In response to further information provided by the Agent (email including the latest revision (03) of their drawing no. DPA-01, Pope Stevens Architecture Ltd.) I conclude as follows:

Drawing No. DPA-01	Revision 03
-----------------------	----------------

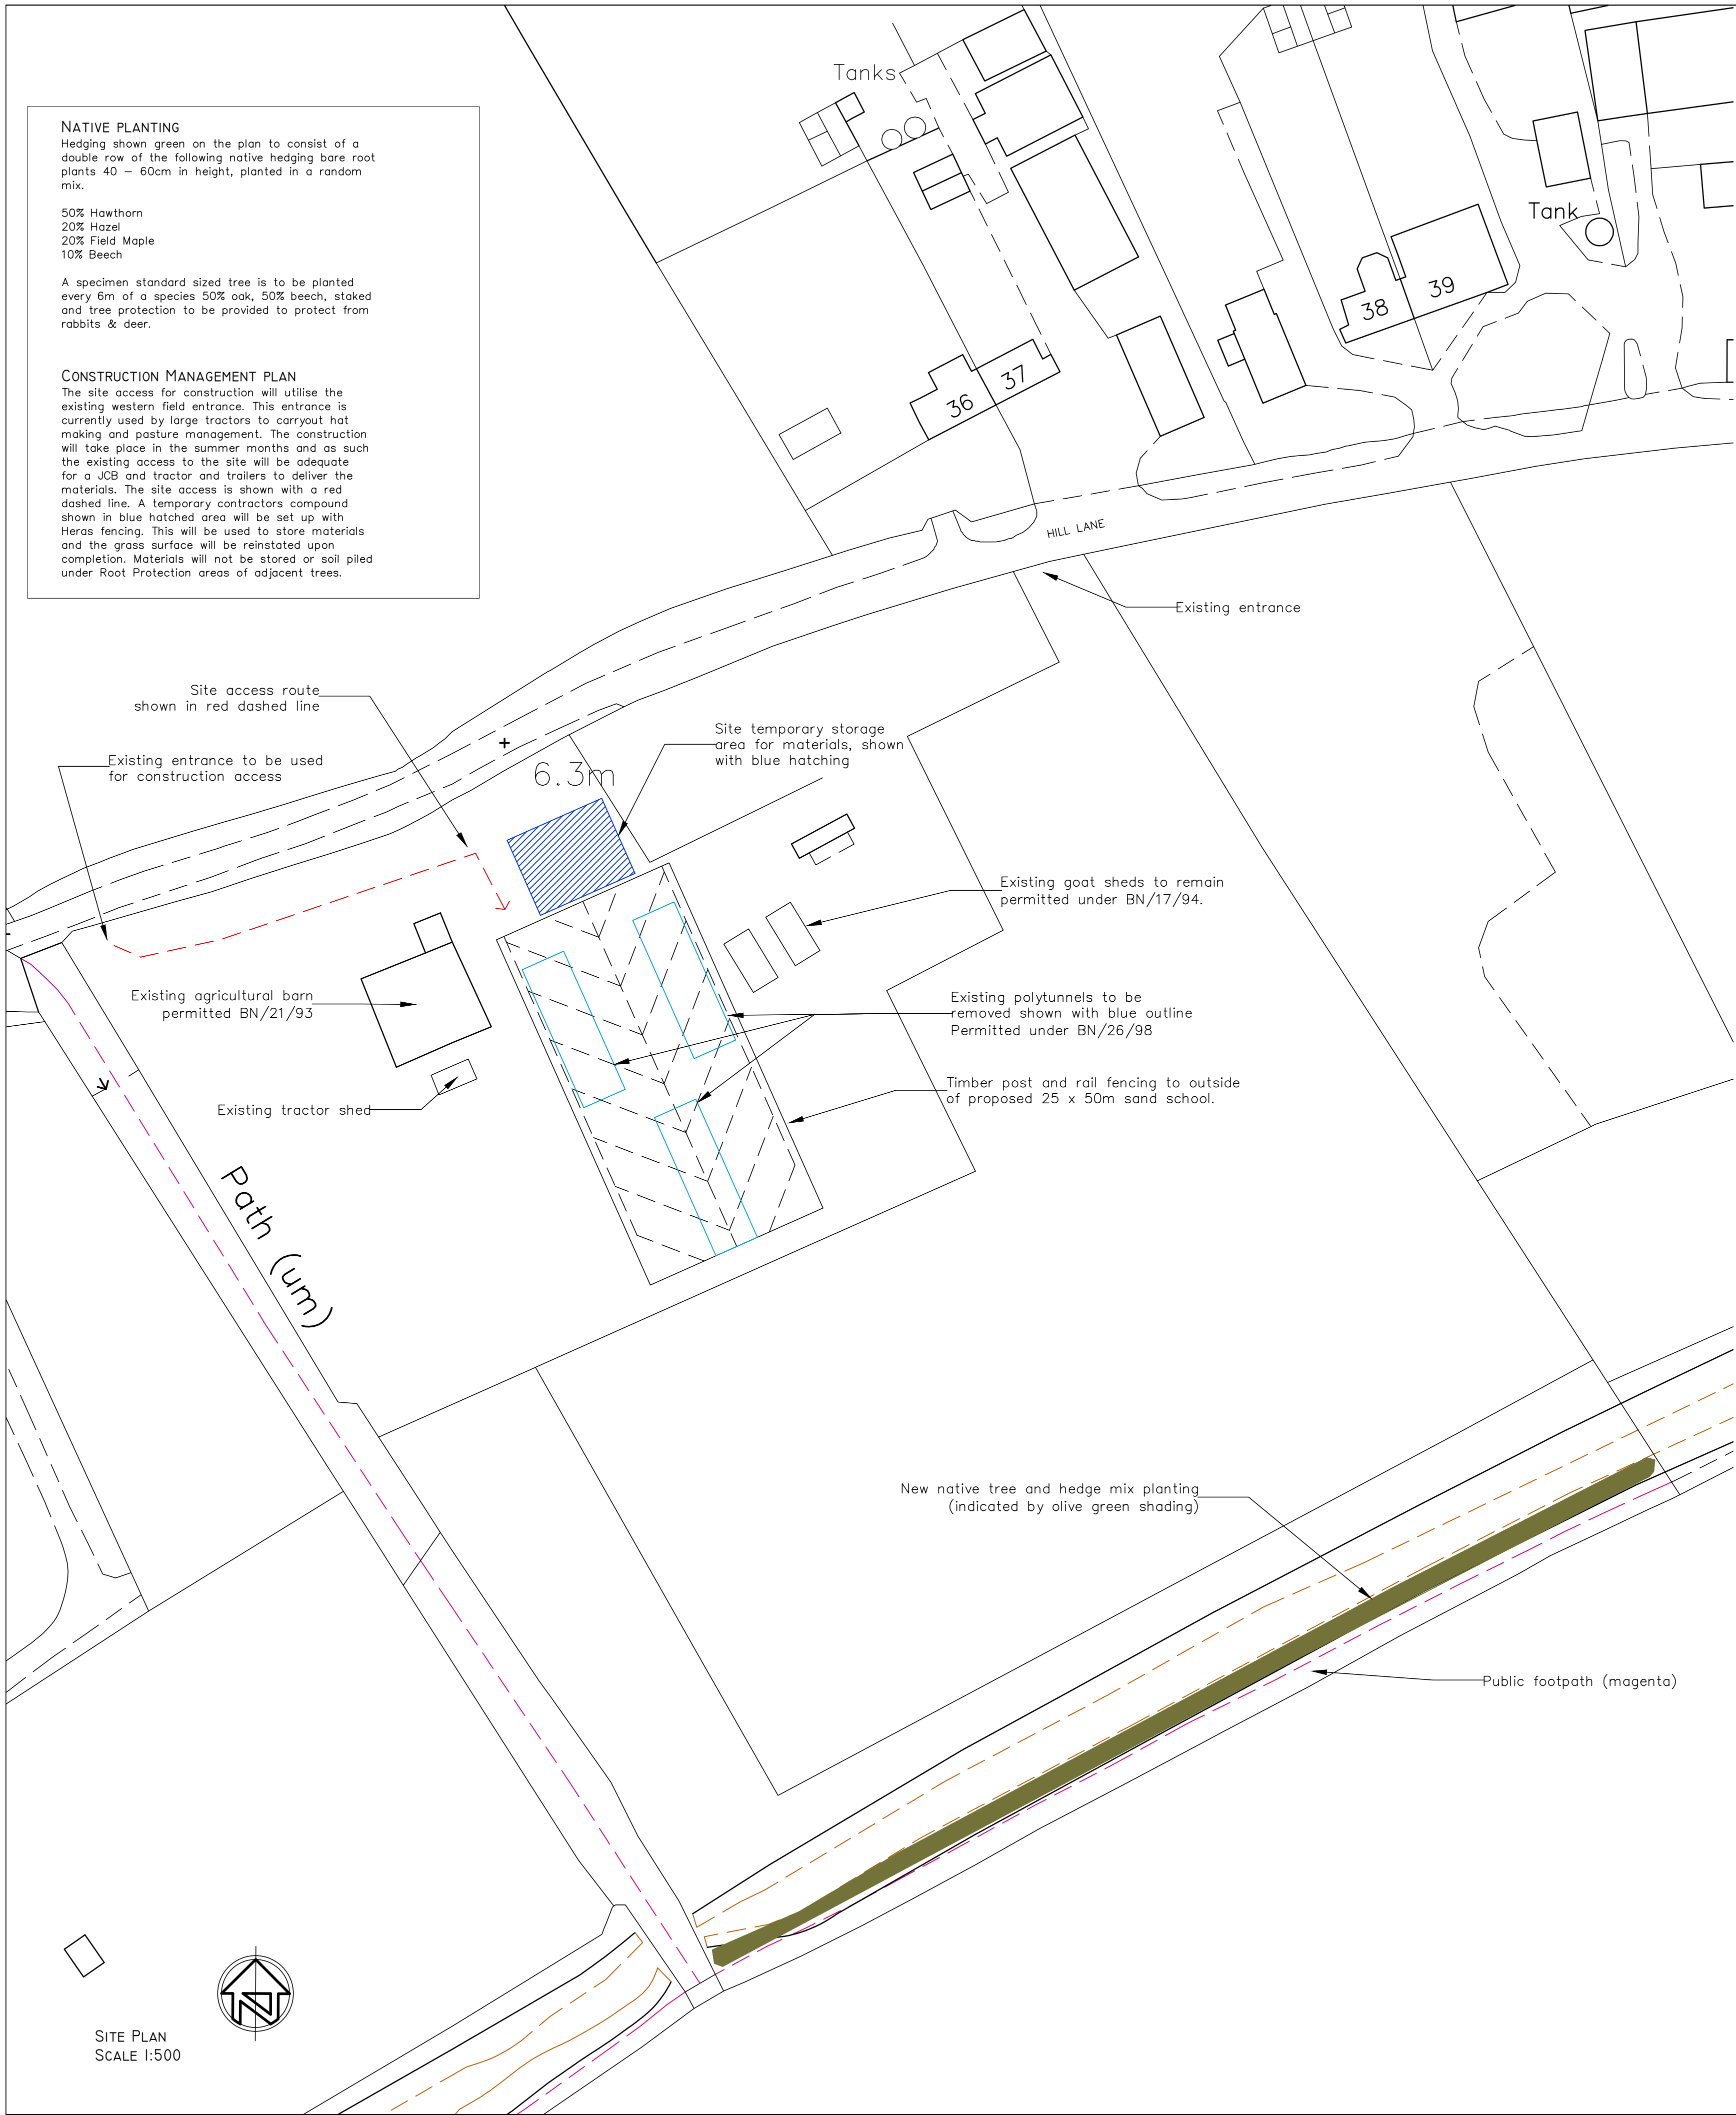
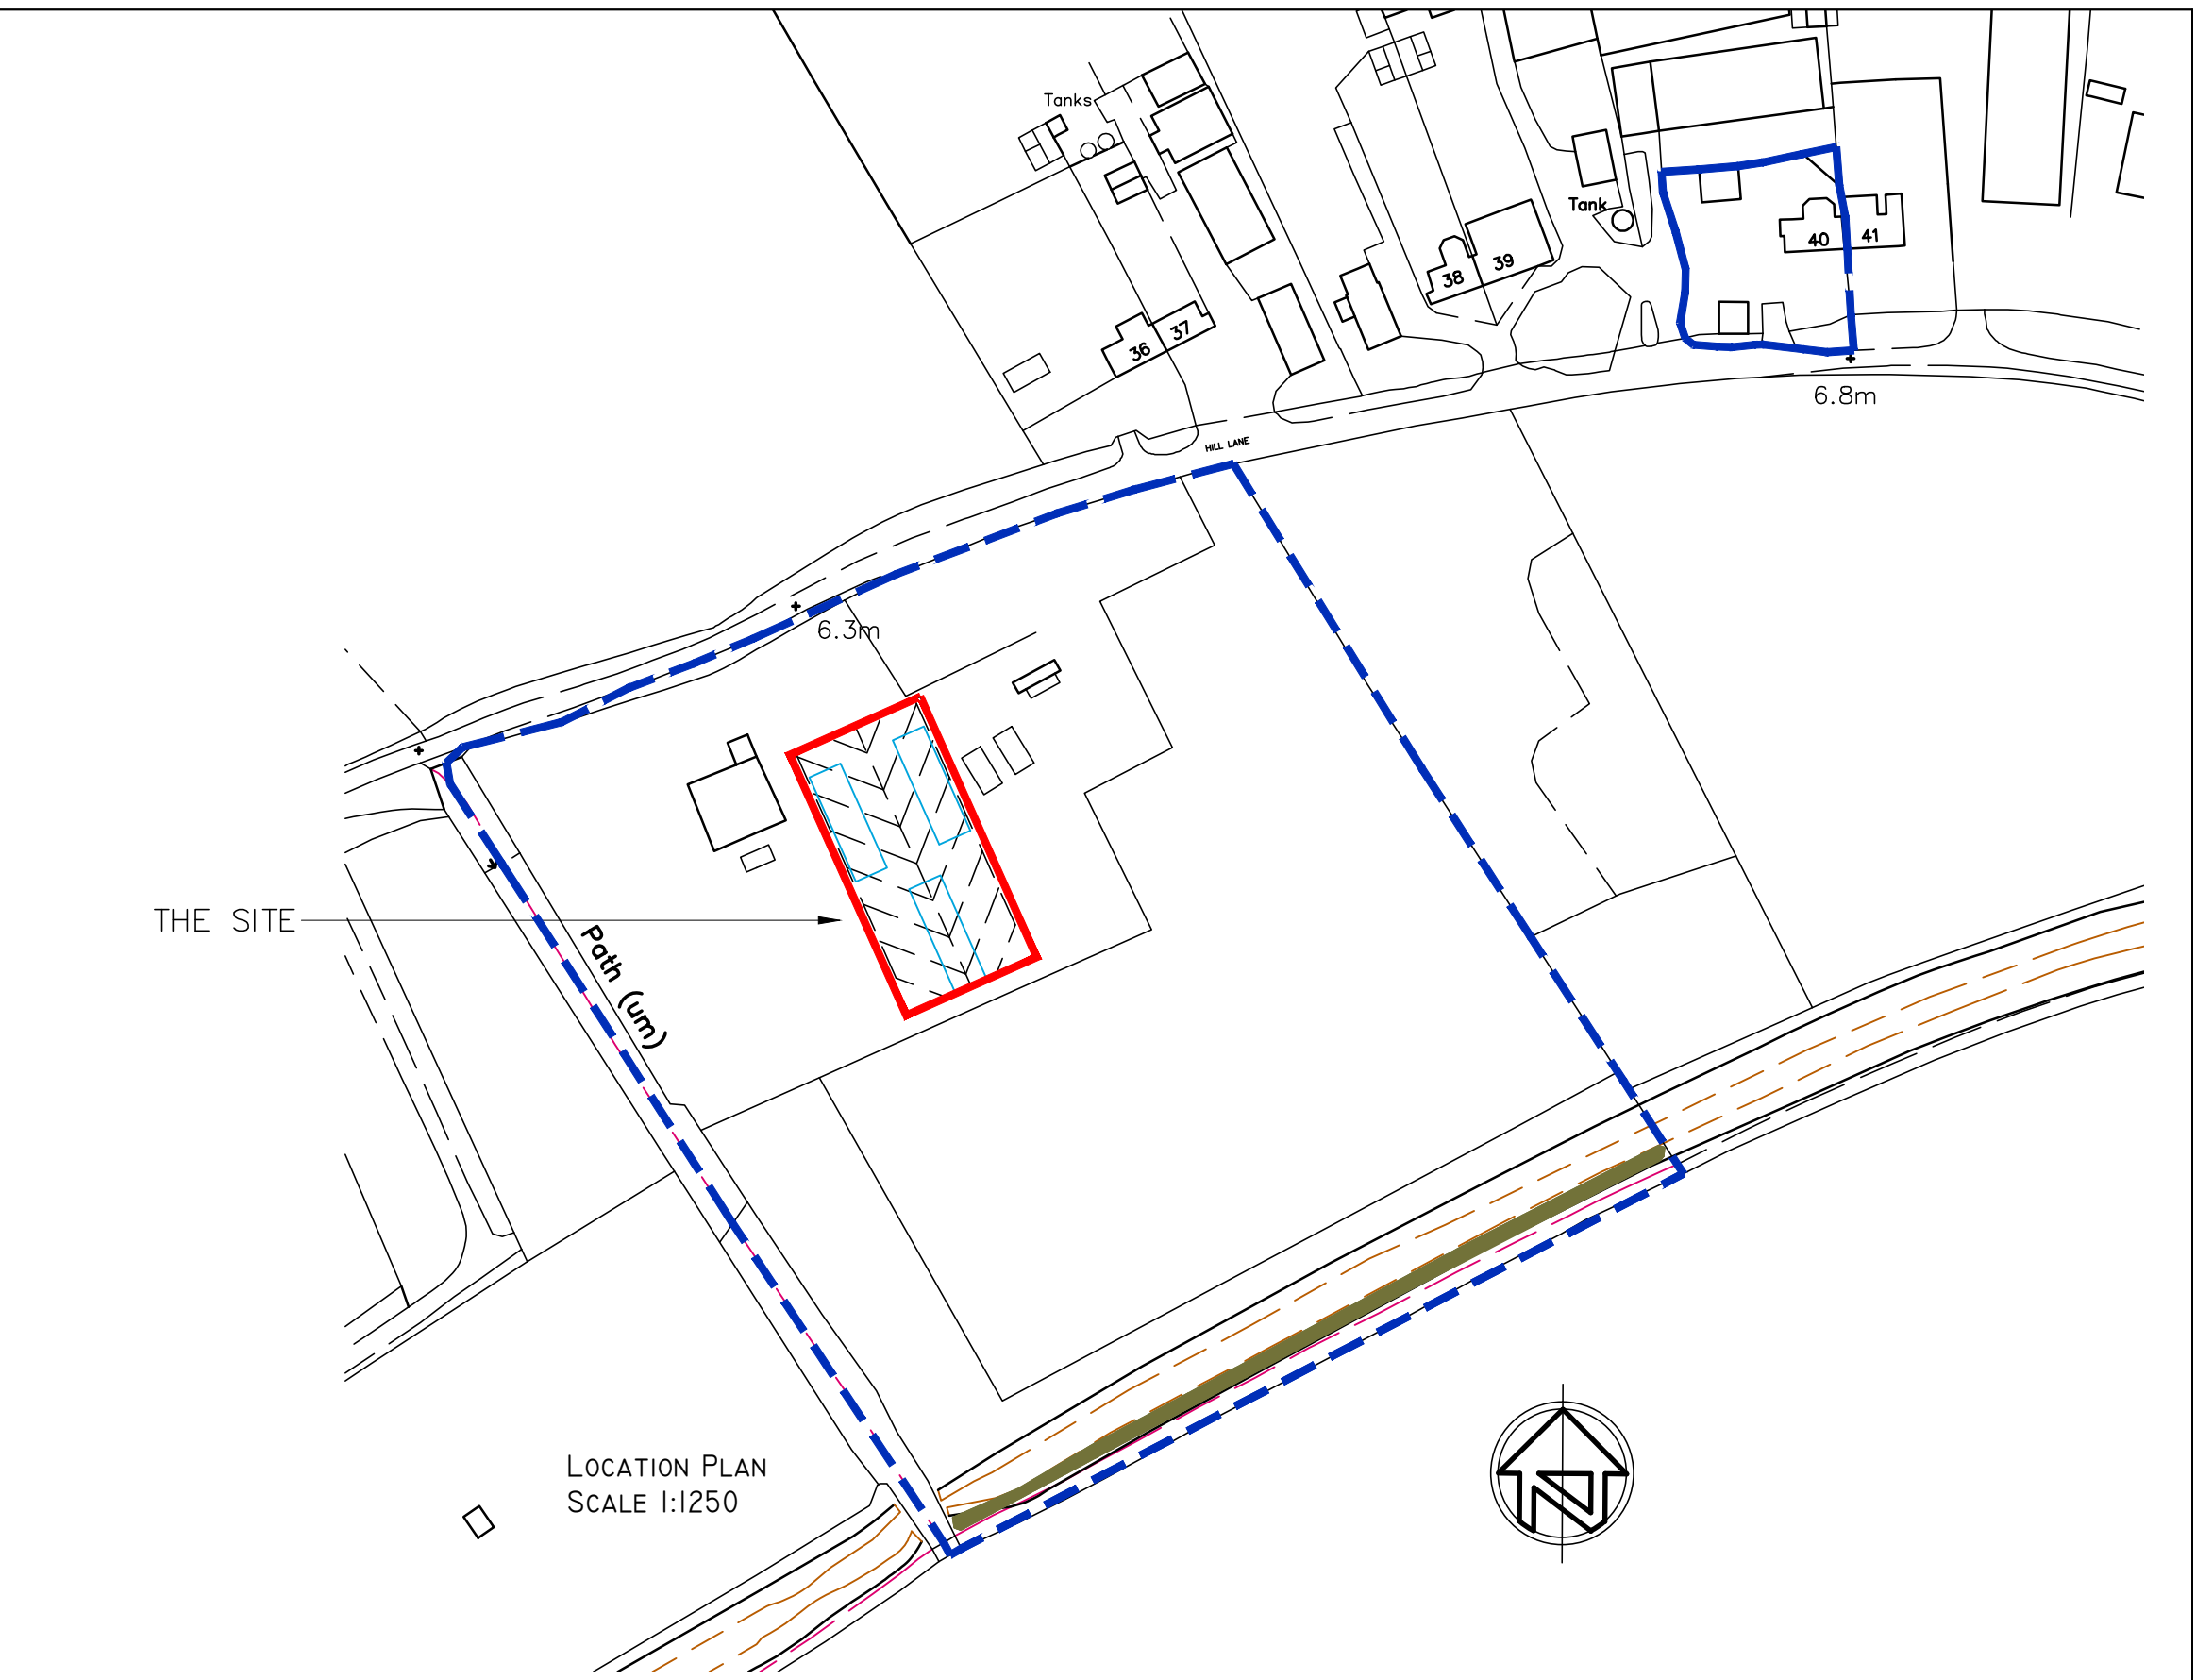
1. The Construction Management Plan describes the heavy plant to be used to deliver materials, single access route in/out of site and compound area for storage of materials. I am satisfied with this plan which should be included in a condition forming part of any APPROVAL.
2. Clarity has been provided around the extent of the native tree/hedgerow planting scheme. Although not as ambitious as first proposed, it nonetheless has the potential to adequately compensate for the removal of those trees around the polytunnels, if adequate aftercare is applied.
